Our ref: NO/2012/104434/02-L01
Your ref: 3/2012/0669
Date: 10 October 2013

**ERECTION OF INDUSTRIAL UNIT AND ALTERATIONS TO PARKING PROVISIONS
LINCOLN WAY, CLITHEROE**

PROPOSED PLANS, ELEVATIONS AND SITE PLAN

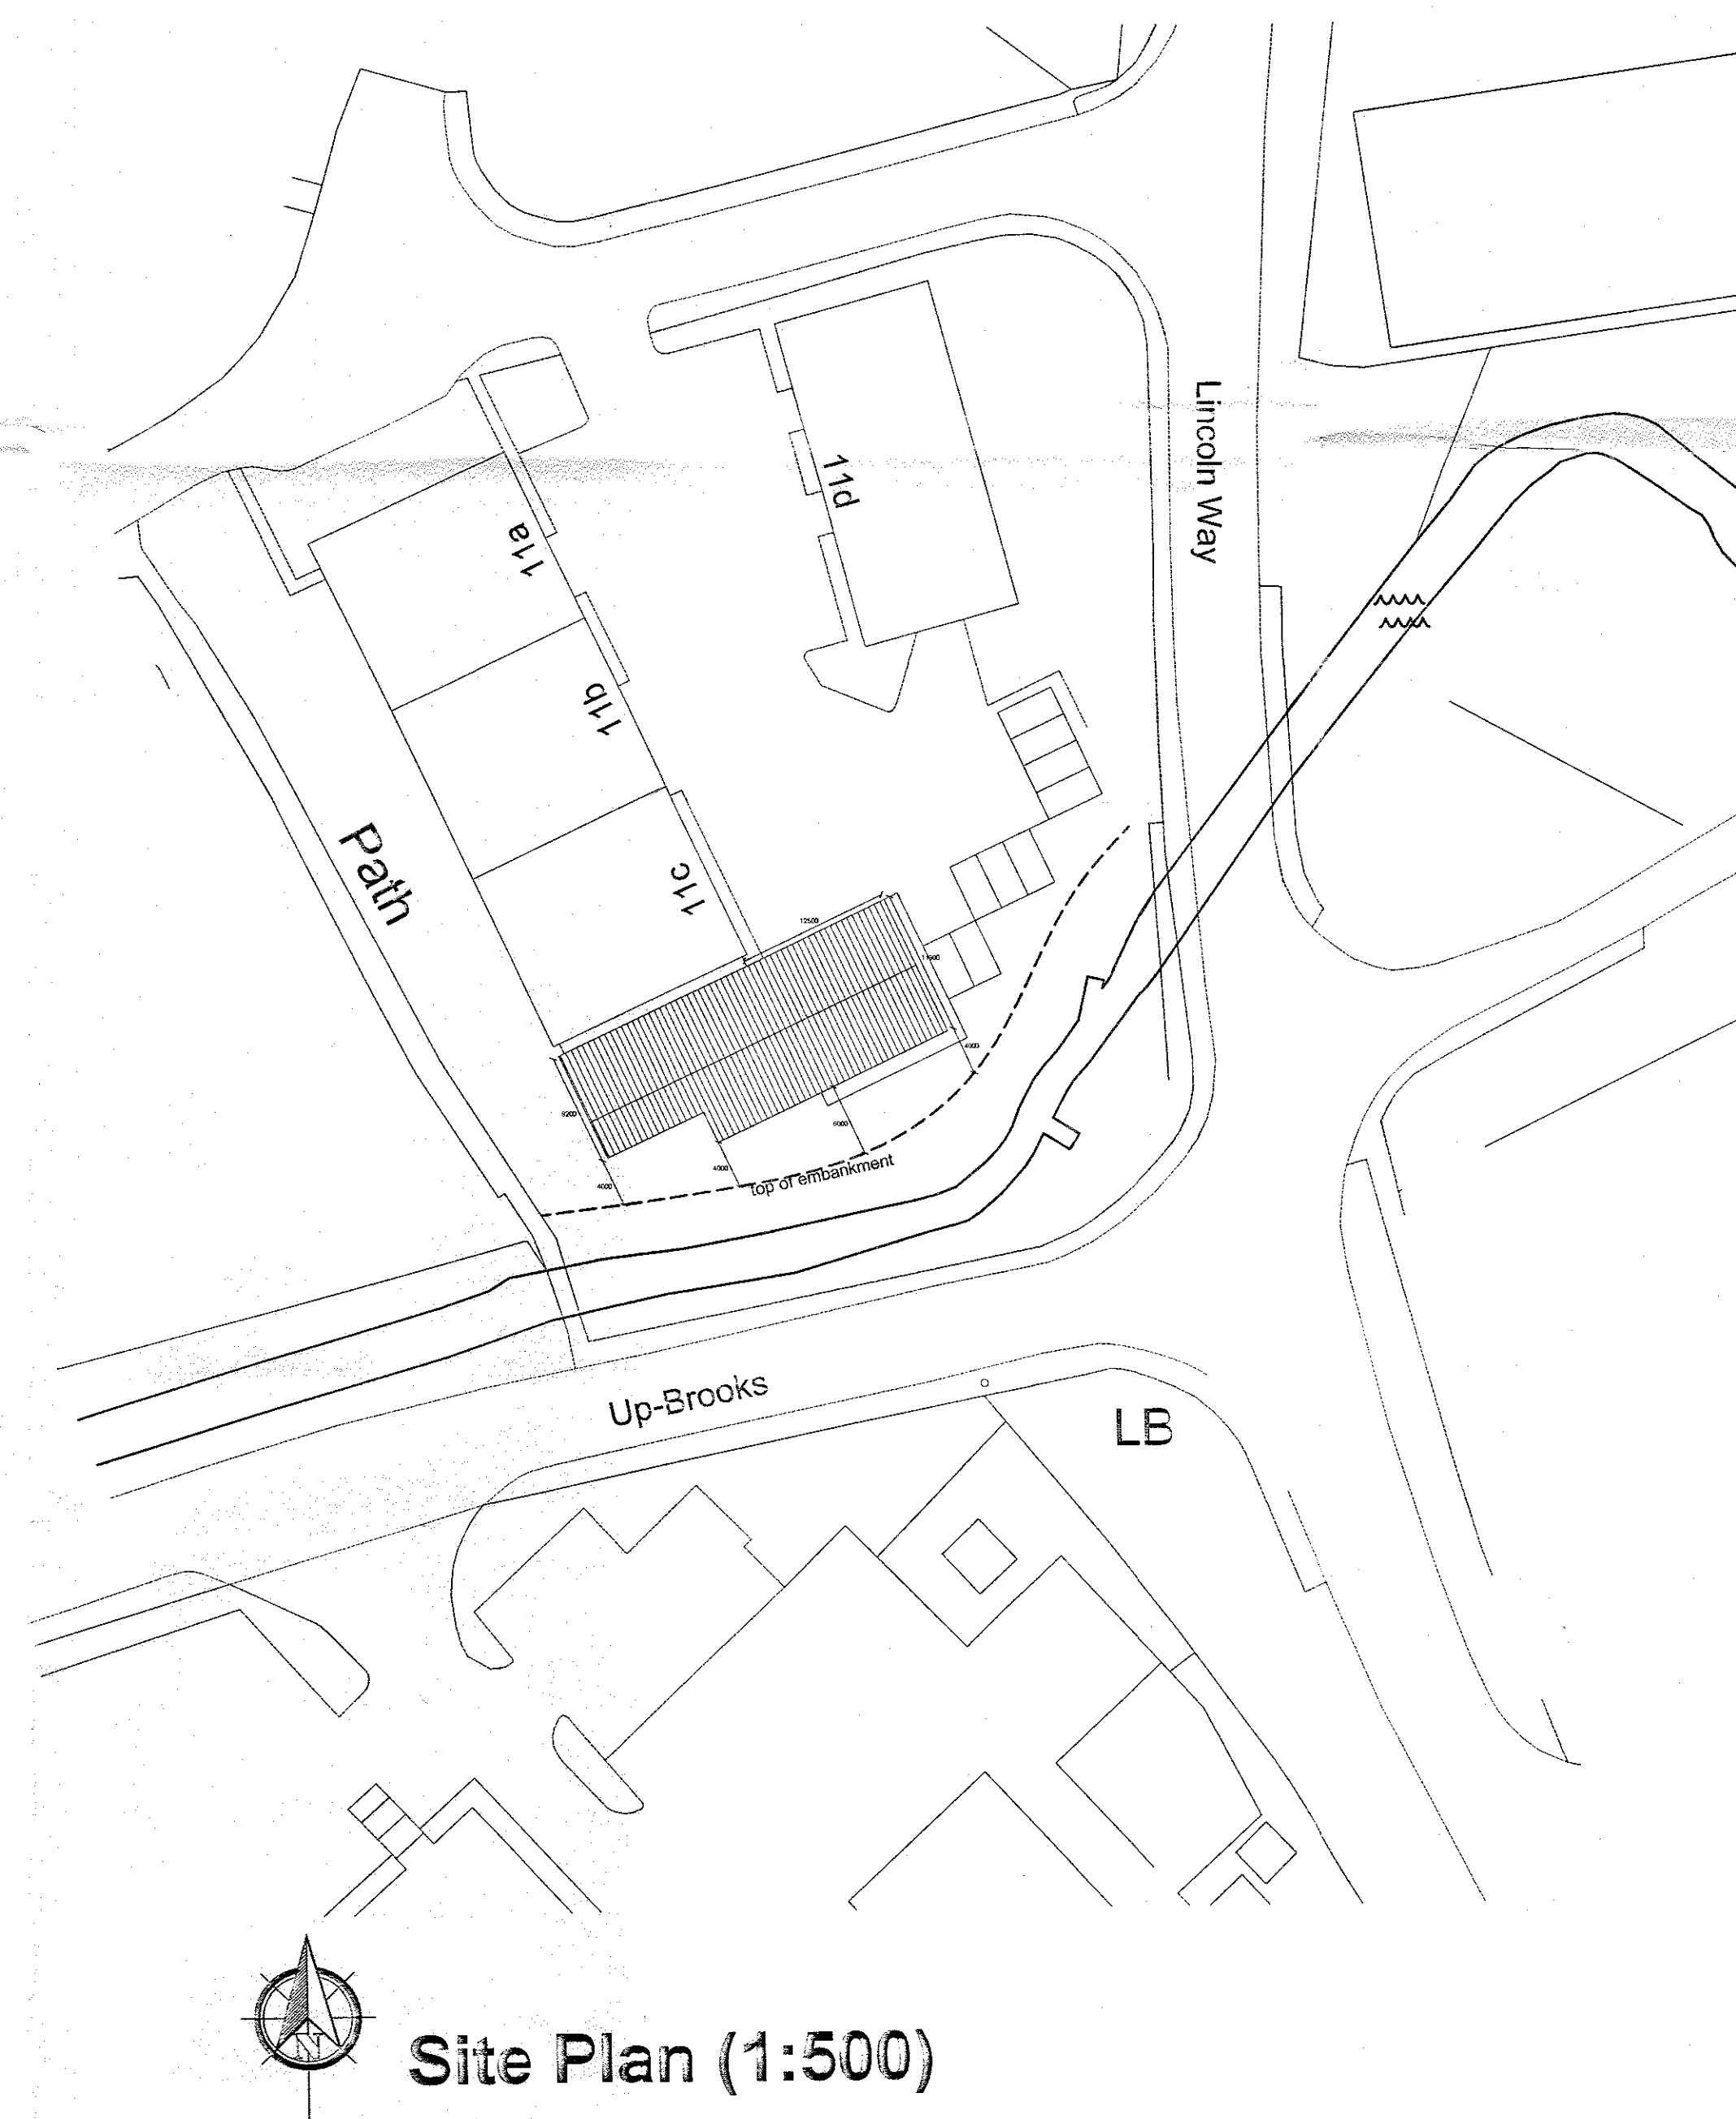
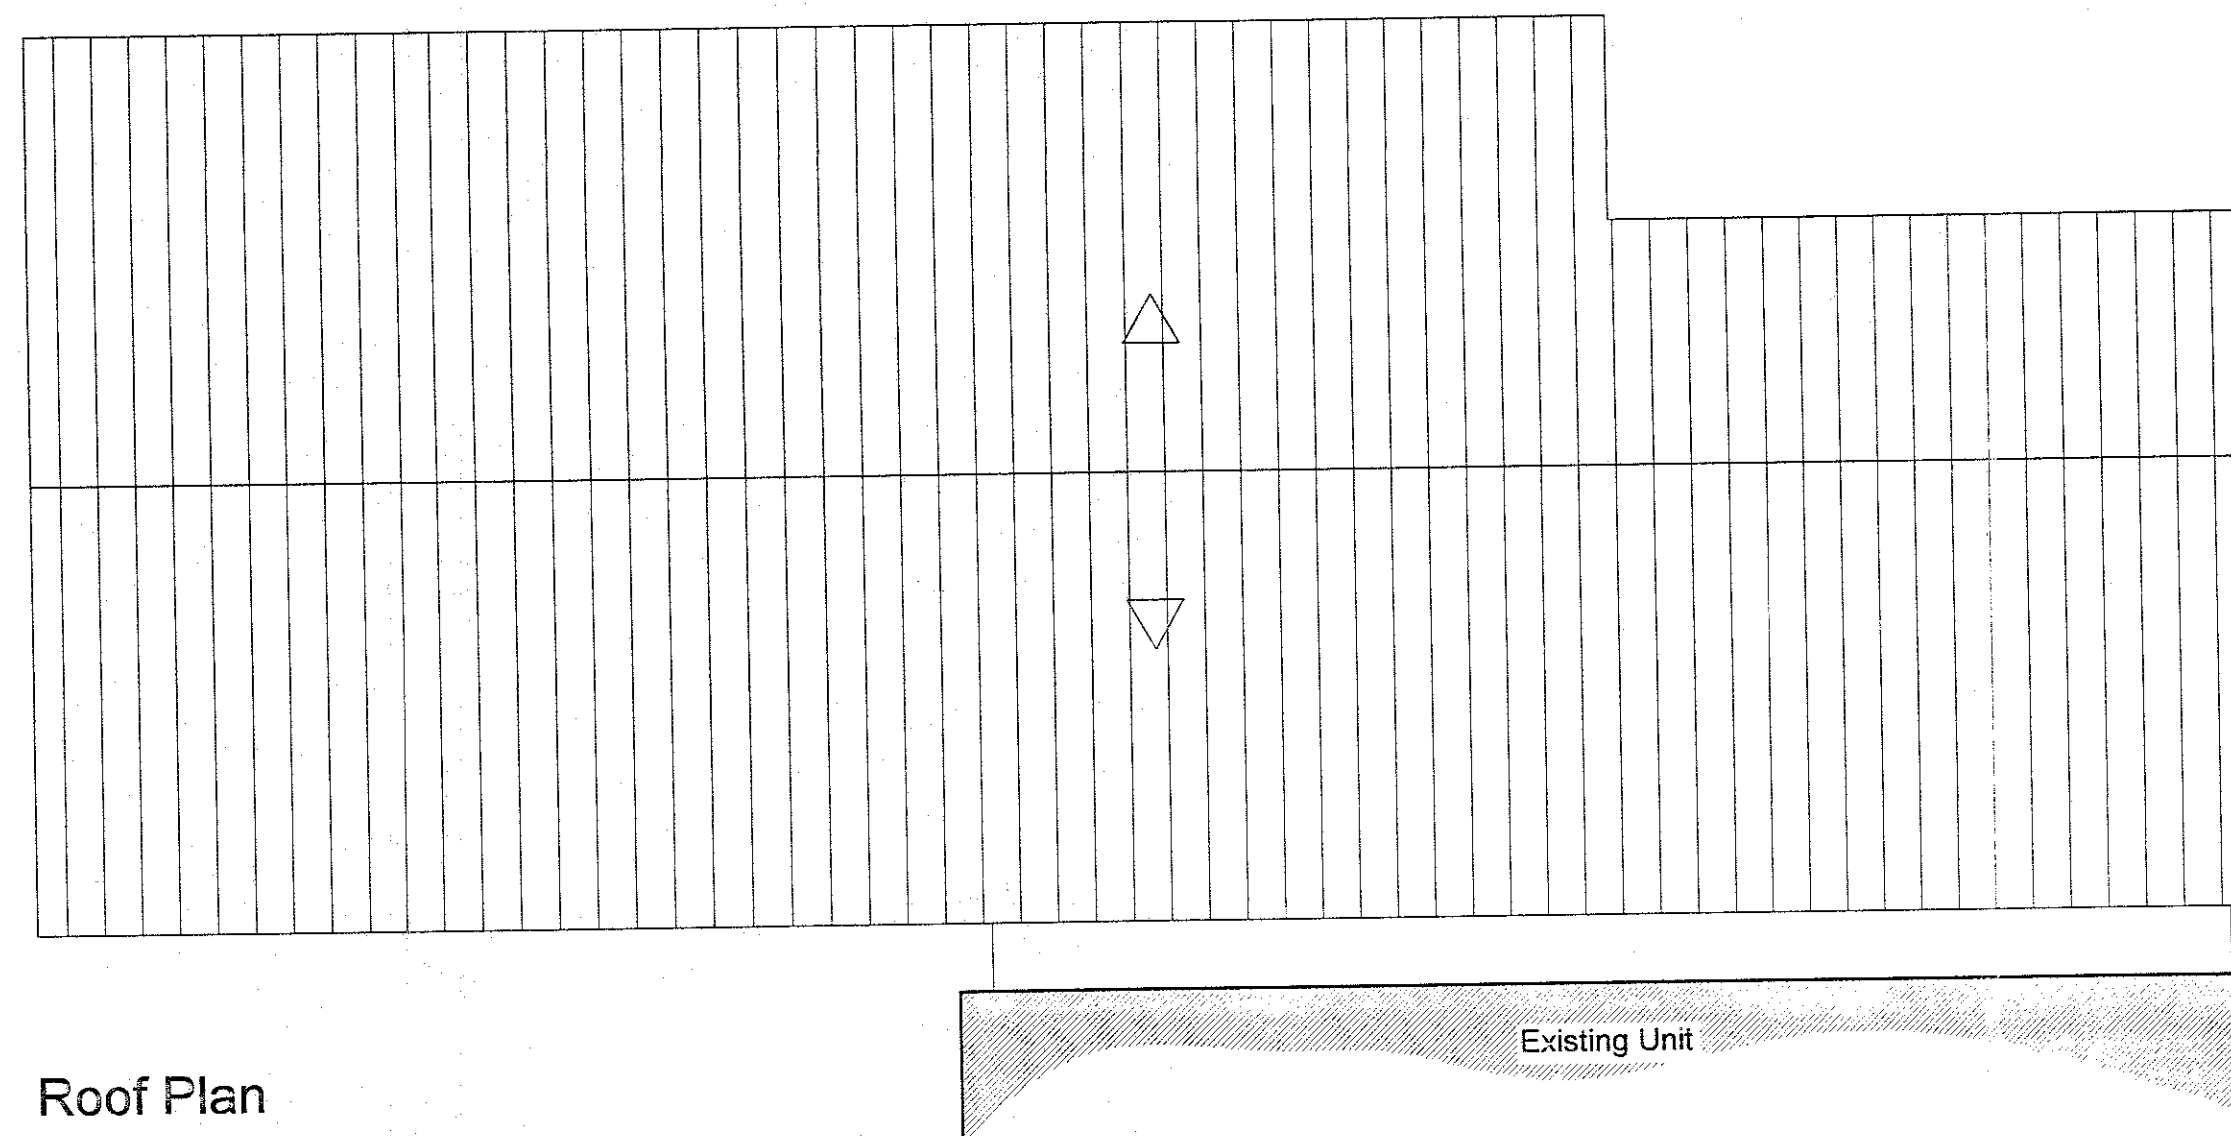
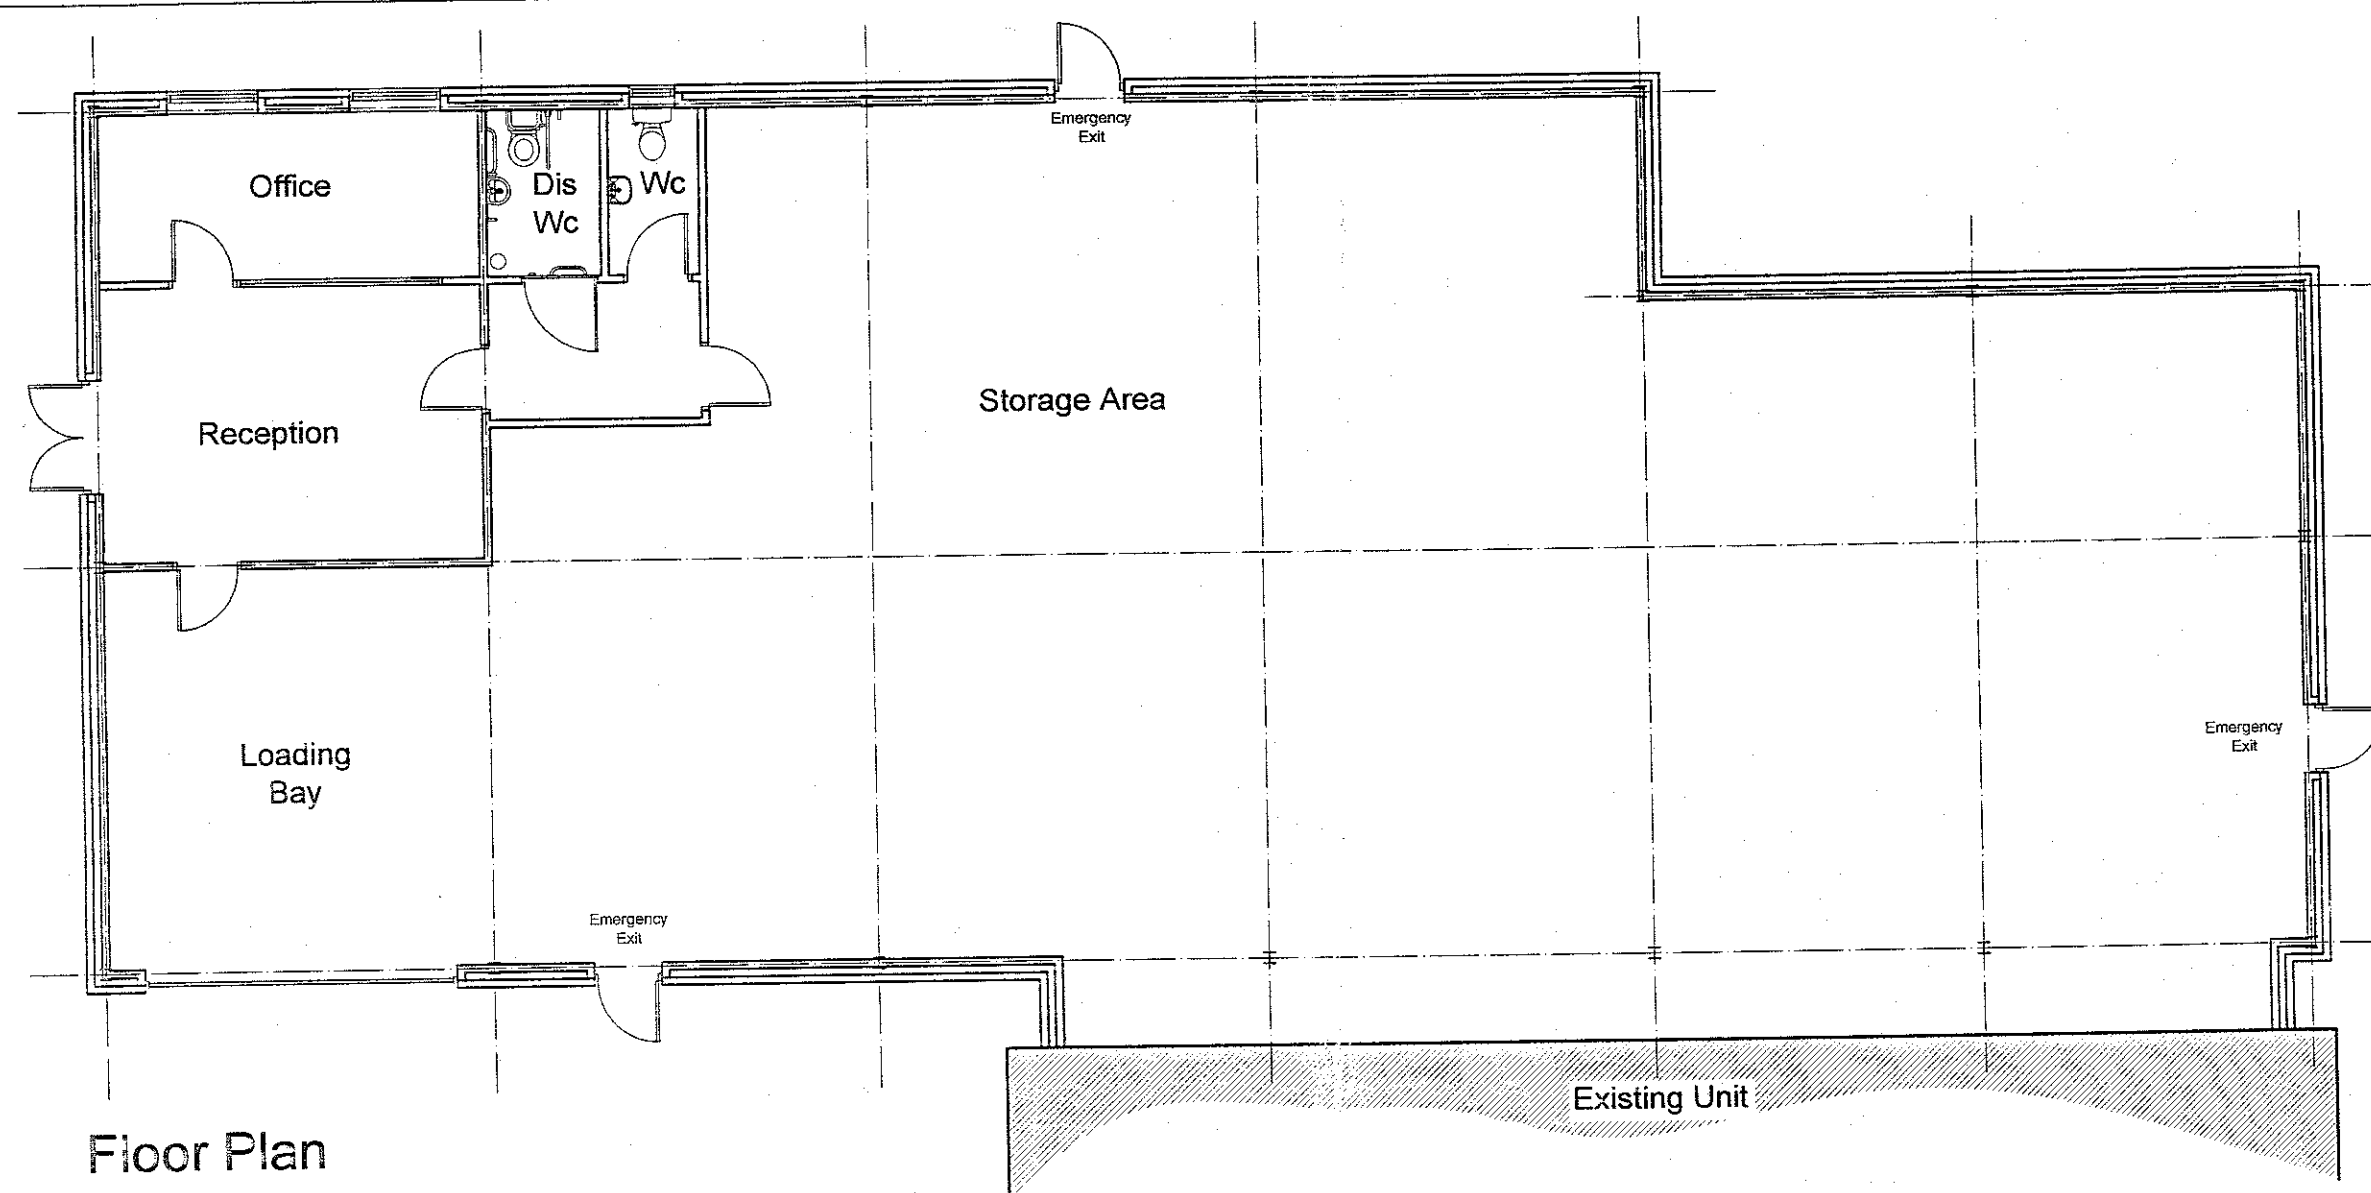
We have met the applicant on site to discuss our access requirements and have agreed to the provision of a 4 metre wide, unobstructed access strip between the proposed building and the top of the bank of Mearley Brook. This is shown in the revised site plan you received on 18 September 2013 and **we withdraw our objection** to the proposed development.
